**Application by Fosse Green Energy Park Limited for an Order
Granting Development Consent for the Fosse Green Energy Park Project**

Deadline 3A Submissions for Lincolnshire County Council (LCC)

LCC Comments on Deadline 2 documents

Bird Mitigation Land Allocation

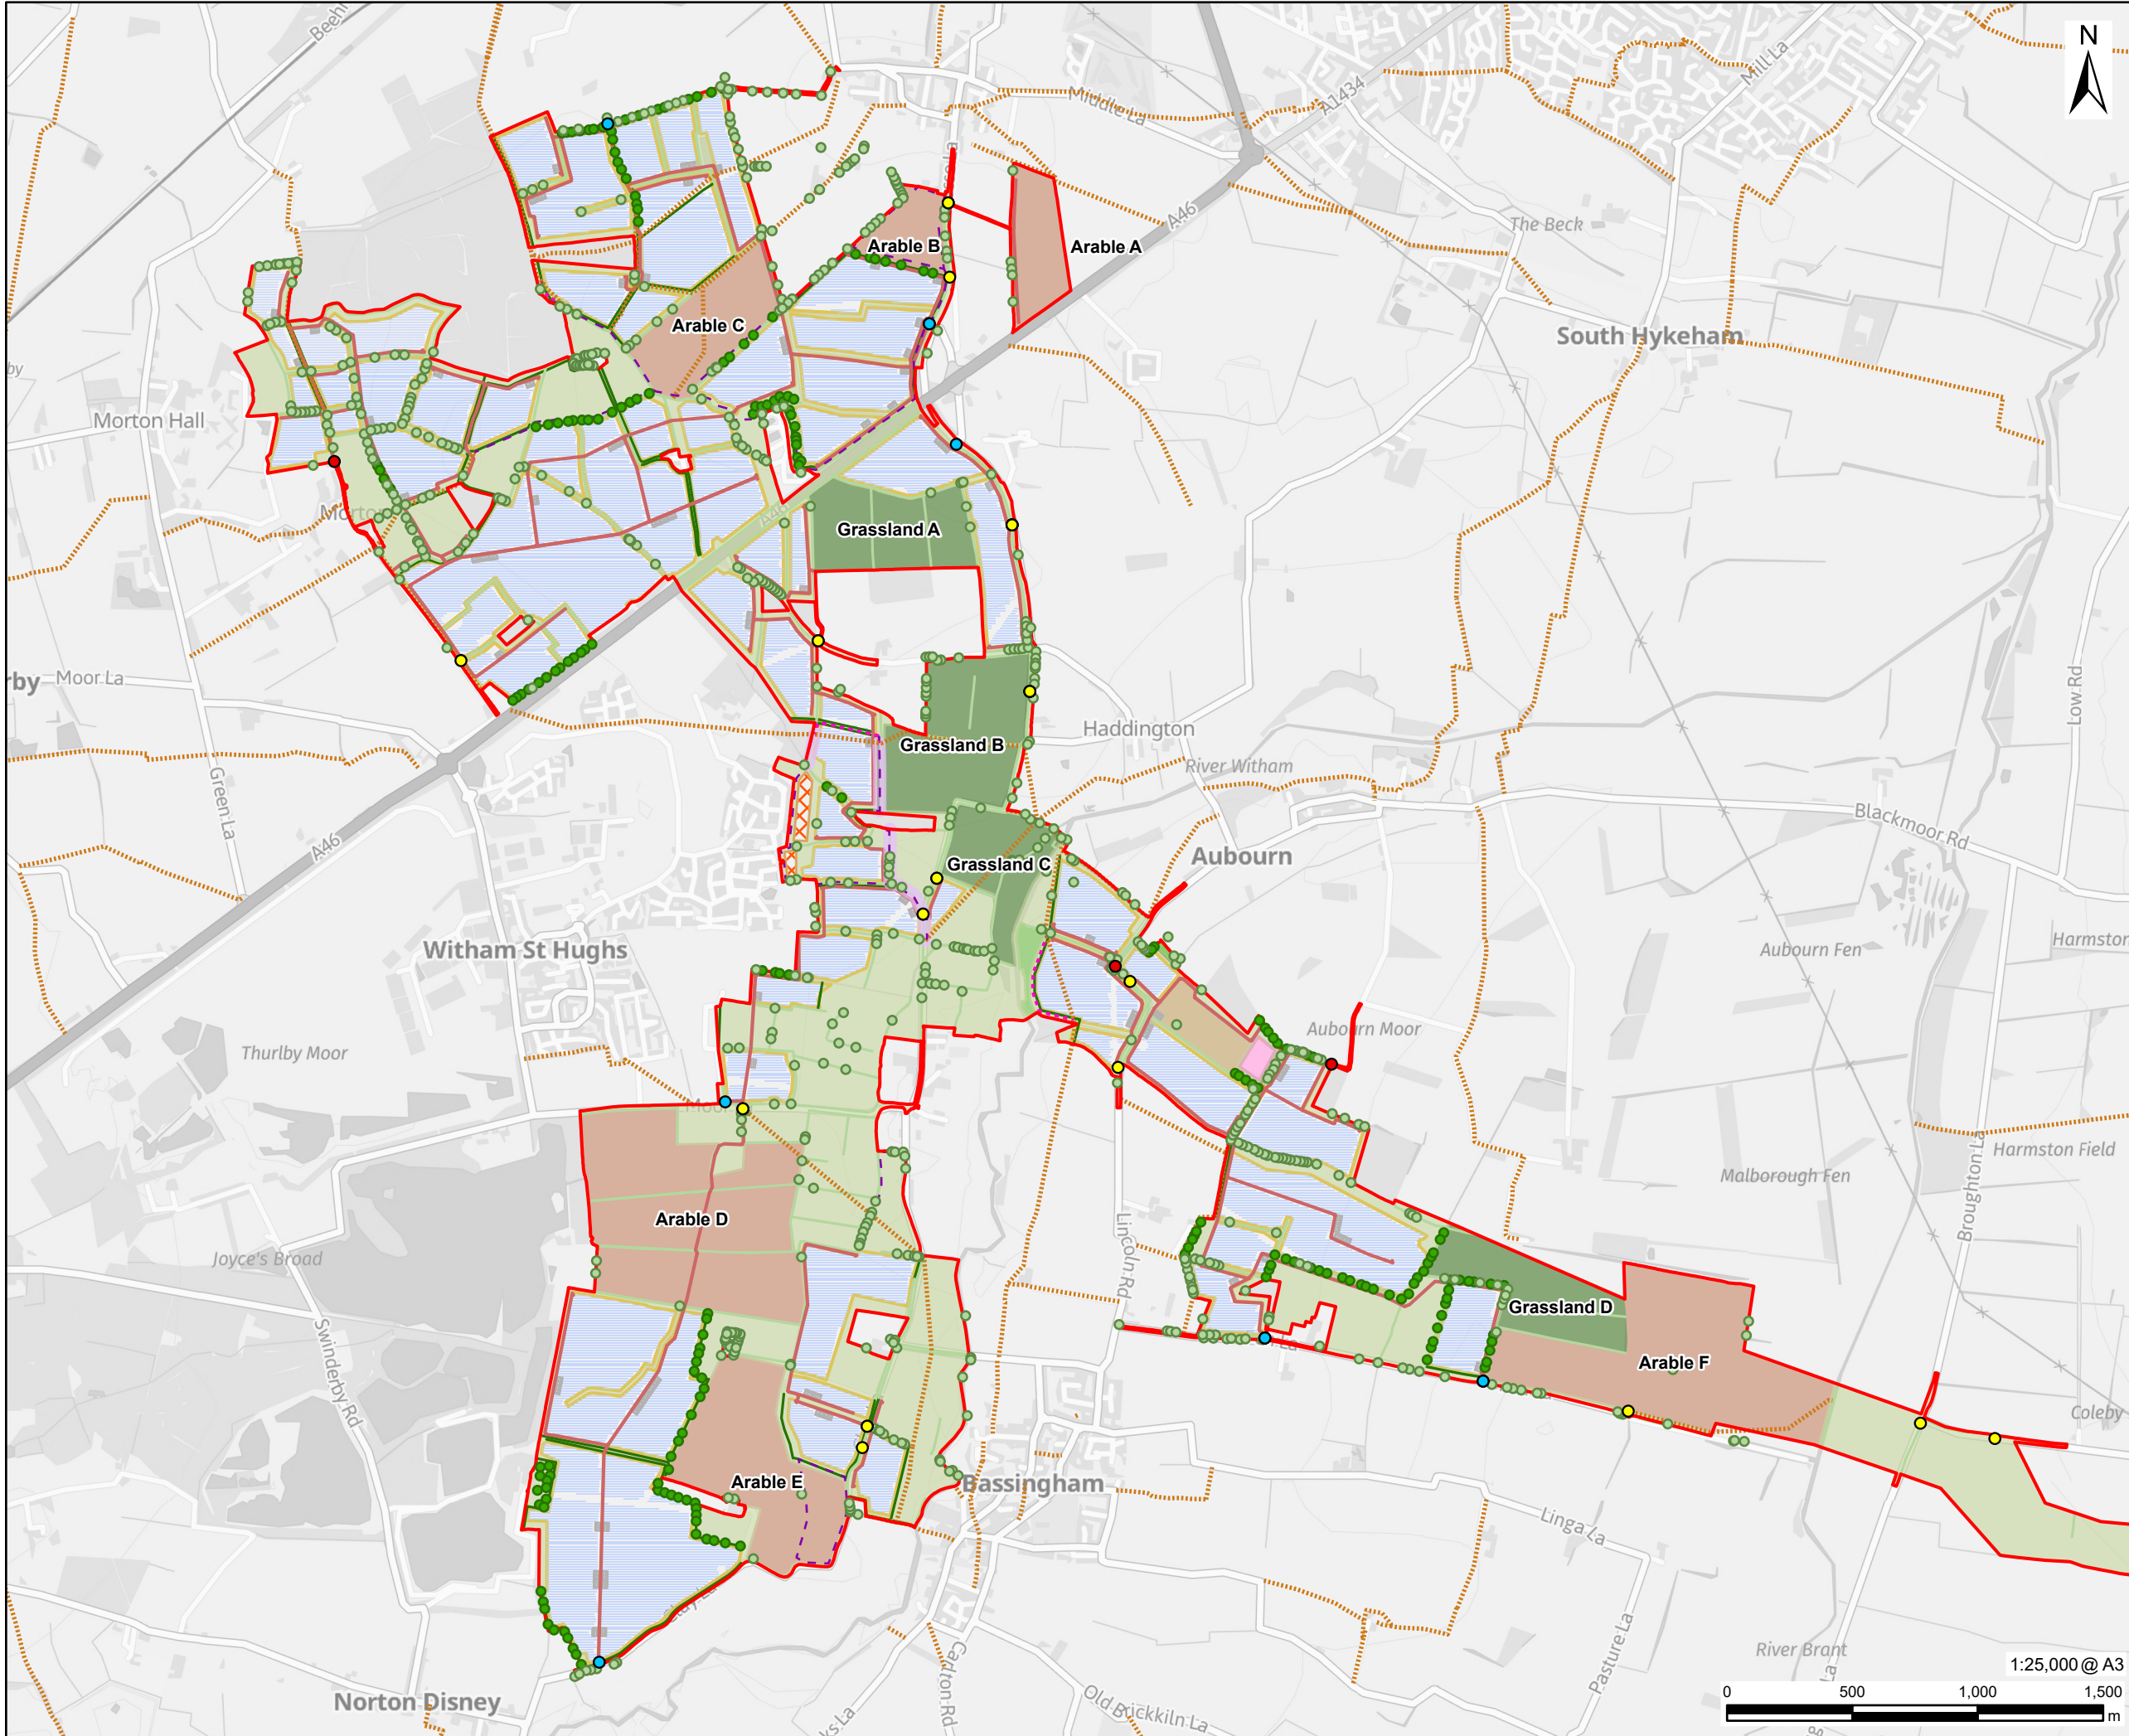
The Applicant identifies that mitigation for ground-nesting birds requires:

- A minimum of 64 ha of permanent grassland.
- A minimum of 181 ha of managed arable land to be managed to provide for the requirements of skylark, lapwing and other ground-nesting species.

These areas are secured through the Framework LEMP and their purpose is to mitigate for the loss of existing arable nesting habitat and ensure no likely significant effect on ground-nesting bird populations. The Council agrees that the areas identified are appropriate and necessary and that their scale is justified.

The Council considers that a reduction in the size or quality of the identified bird mitigation areas would be unacceptable, as it would risk compromising the provision of effective mitigation for ground-nesting birds. Such a reduction would also be likely to negatively impact the predicted BNG outcomes, particularly given the contribution that habitat enhancement associated with the bird mitigation areas makes to the Applicant's BNG calculations.

The Council therefore agrees with the Applicant's approach to defining land requirements for both ground-nesting bird mitigation and BNG and is of the opinion that the areas identified are necessary, appropriate, and proportionate.

Local Landscape Character Areas

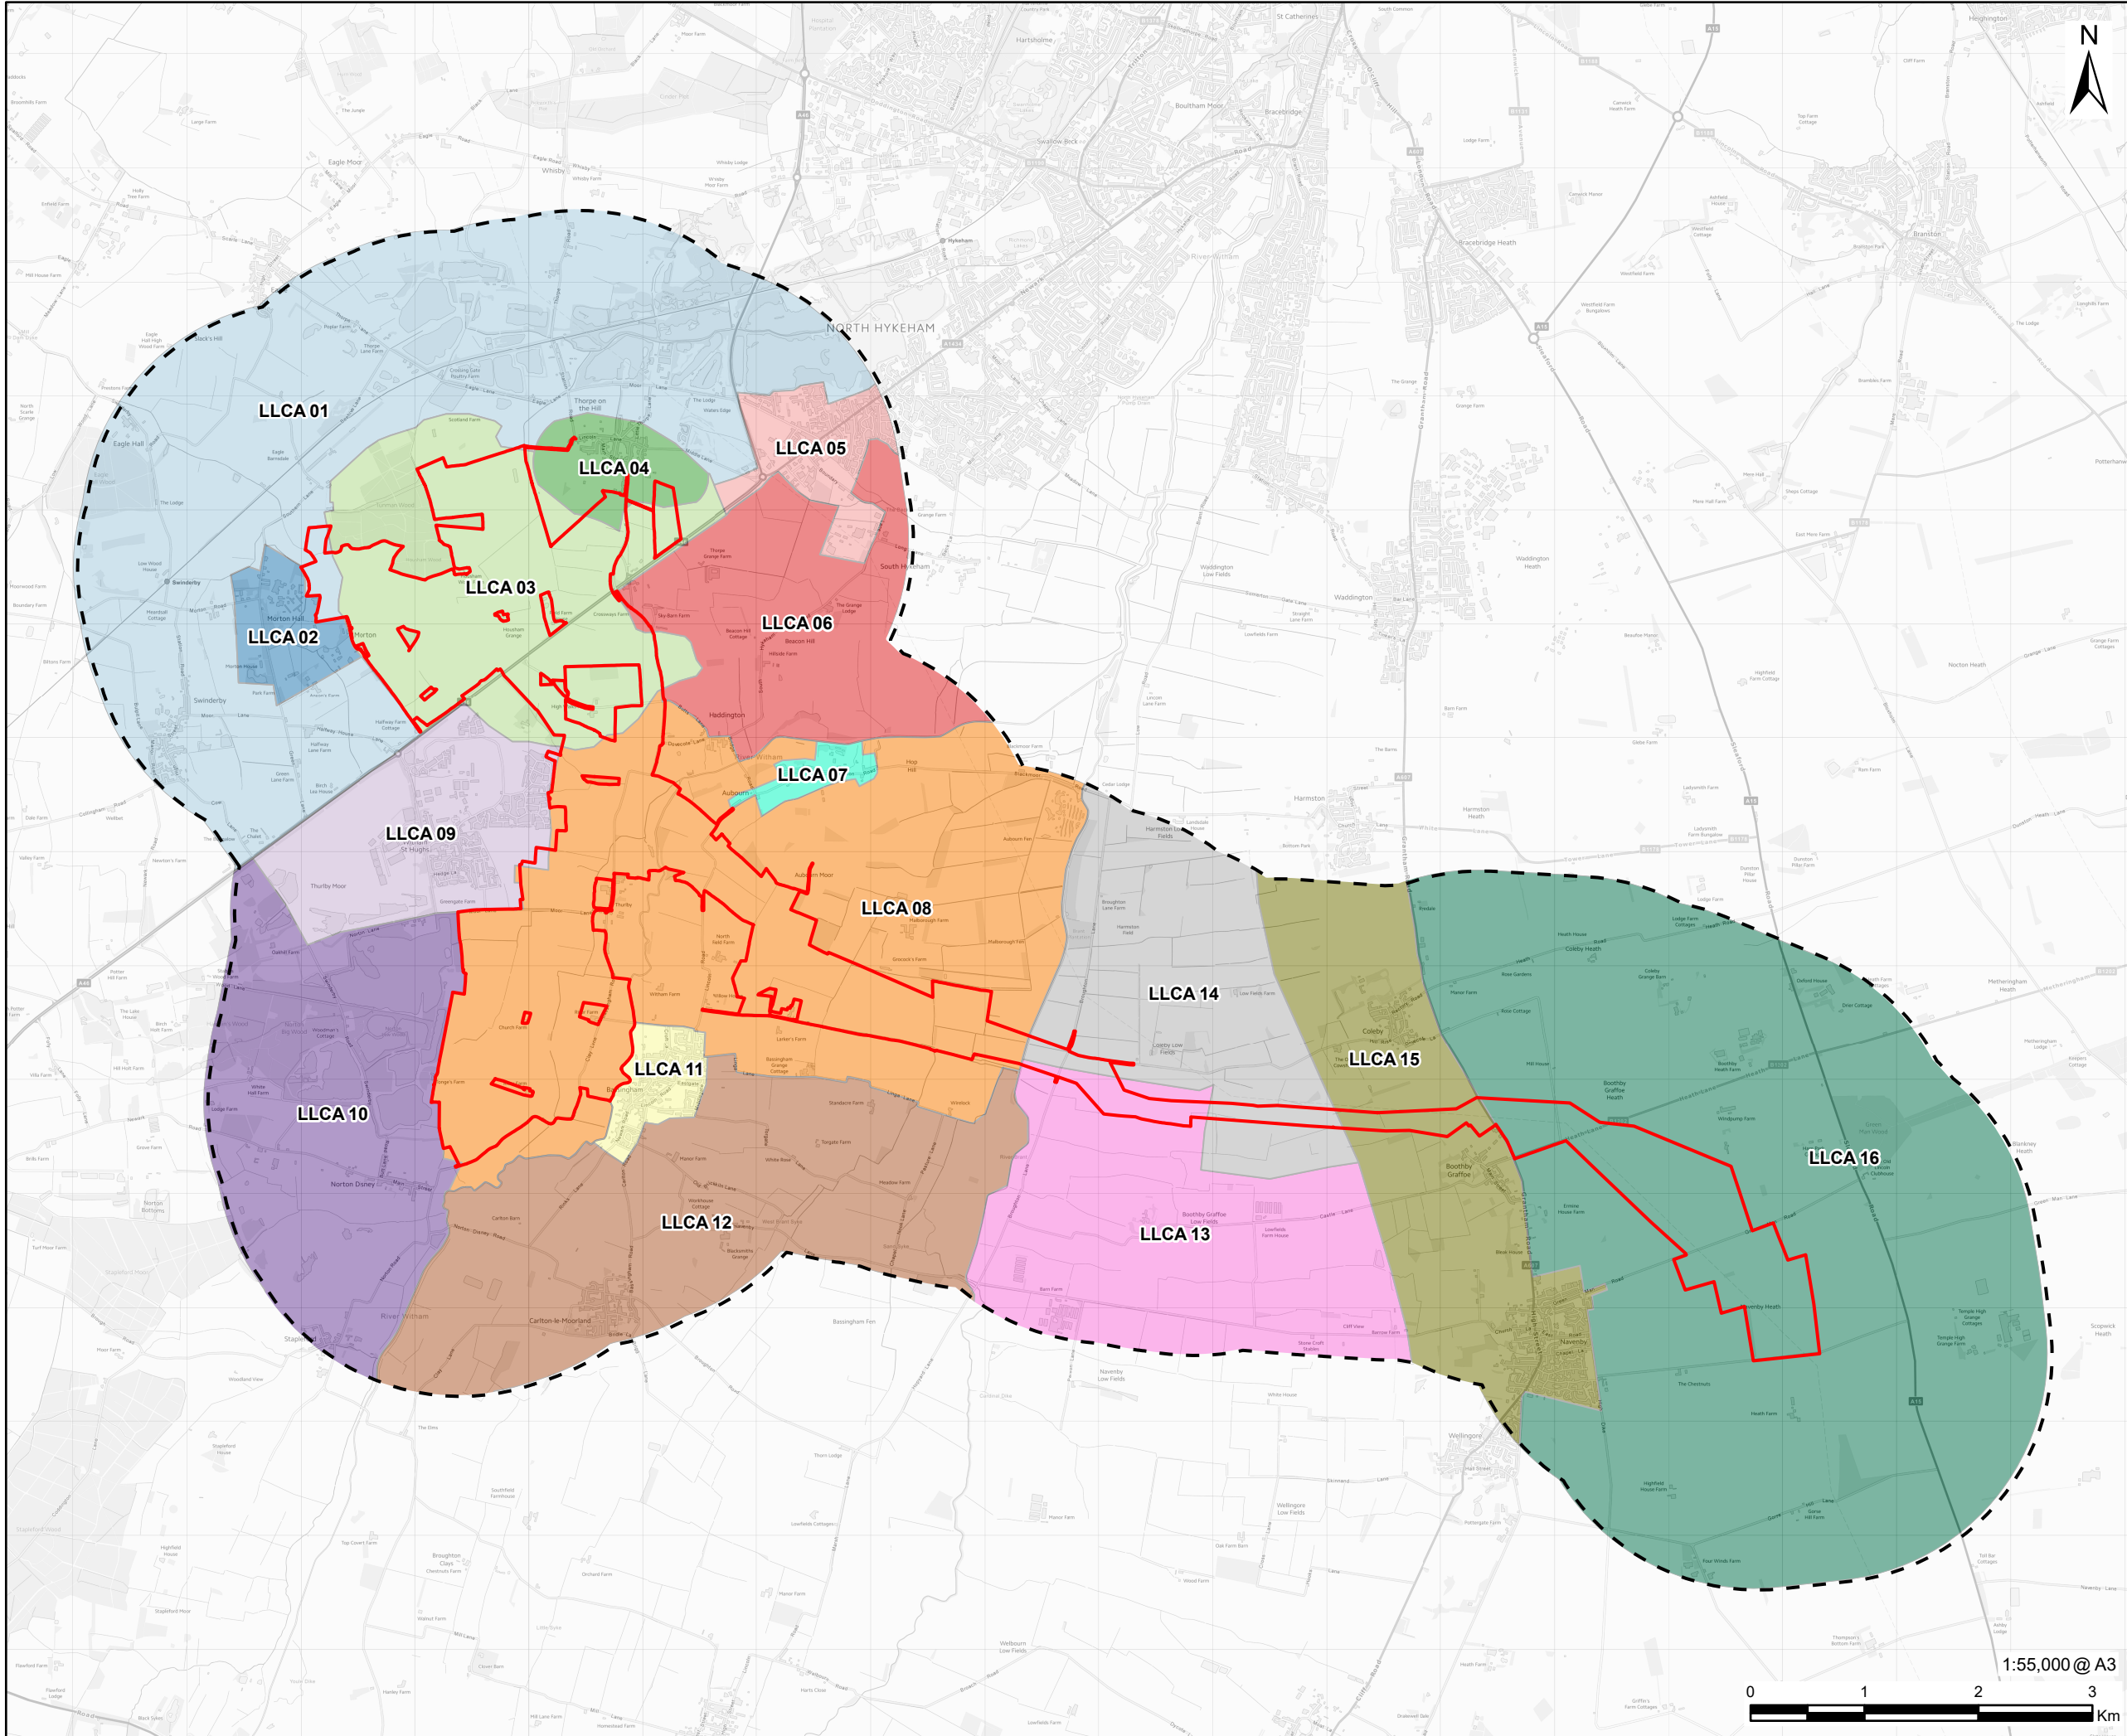
9.17 – LCC are concerned about the effects of the development on the Principal site and the LLCAs 03: Tunman Hill and LLCA 06: Thurlby Fenland. These are assessed as Moderate adverse (not significant) during operation, however, LCC believe there will be direct and long terms effects that will be significant. Once again, heavy reliance is placed on the 'establishment and maturation' of mitigation planting.

9.18 – The applicant's response suggests perceived changes would be limited 'to a small geographic extent and therefore only a subtle alteration to the landscape character'. This might be the case if only individual LCTs and LLCAs were affected, but LCC have concerns about the cumulative understating of several LCTs and LLCAs (LCT 4a: Wooded Vales, LLCA 03: Tunman Hill, LLCA 08: Thurlby Fenland etc) which if considered together will result in adverse effects that are extensive.
